2nd July 2023

Re: Single Dwelling Application 2023/90958

01 Building Section
1:100

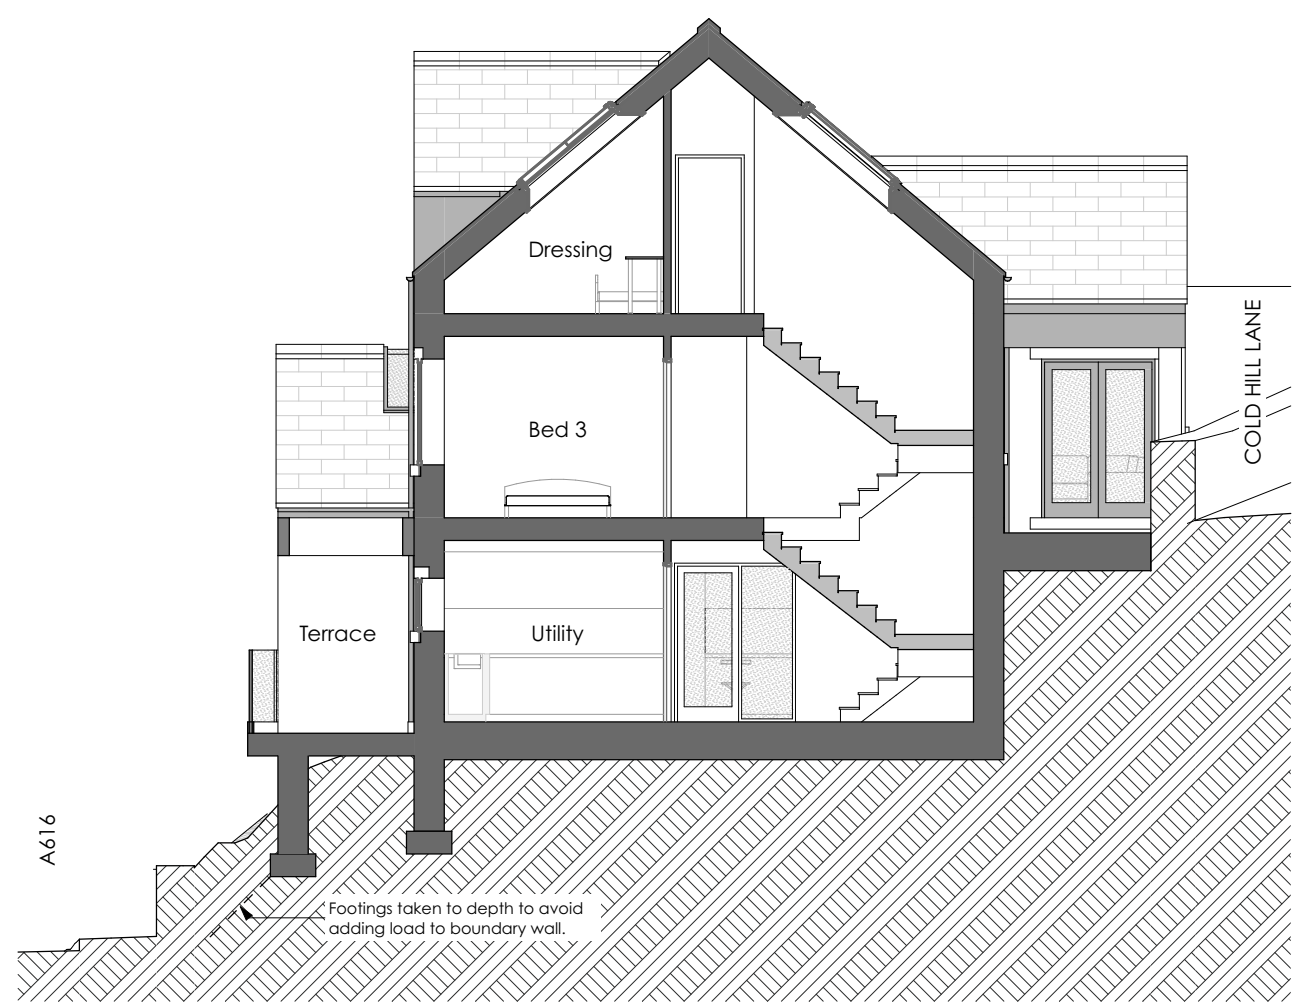
We note that the supporting visual, projection 5, does not show the proposed dwelling in its true light. It seems to suggest that the property would have a much lower roof pitch compared with the 01 Building Section and the East elevation grouped plan. We feel this may be deliberate action so as not to draw attention to the overall height of the building.

North Elevation
1:100

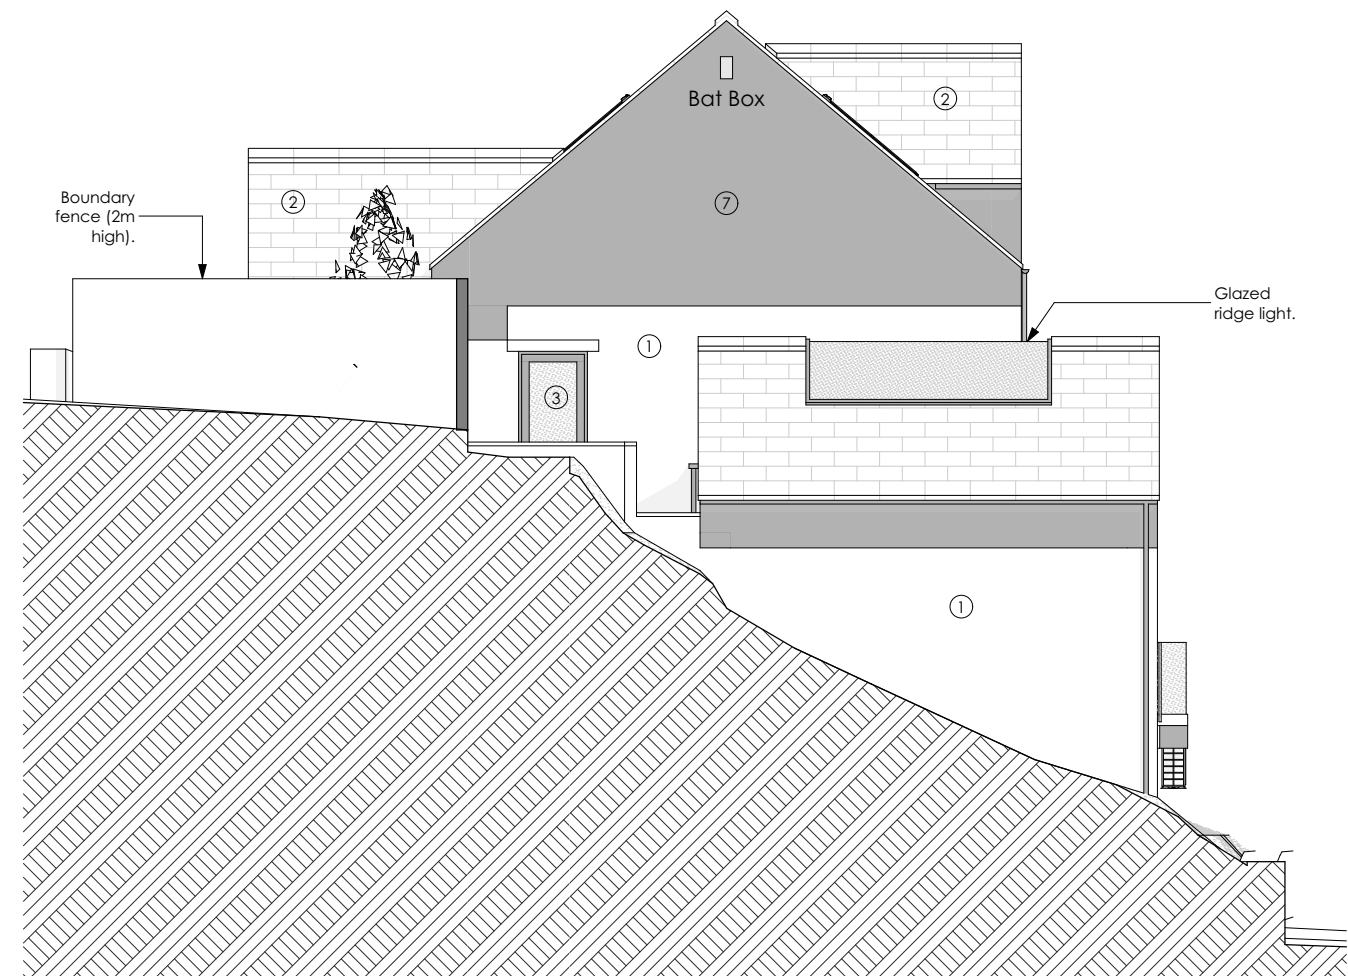
We see from the application that it is proposed to incorporate a main bedroom, en-suite and dressing room within the roof space thus creating the third floor. This being the case, the North elevation is proposed to be clad in a 'Black' material creating a very large, almost 'monolithic' imposing visual structure. The third floor will also be very dominant on the East elevation facing Cold Hill Lane. We feel this to be far too high given its proximity to Hillside House and its boundaries as well as Cold Hill Lane.
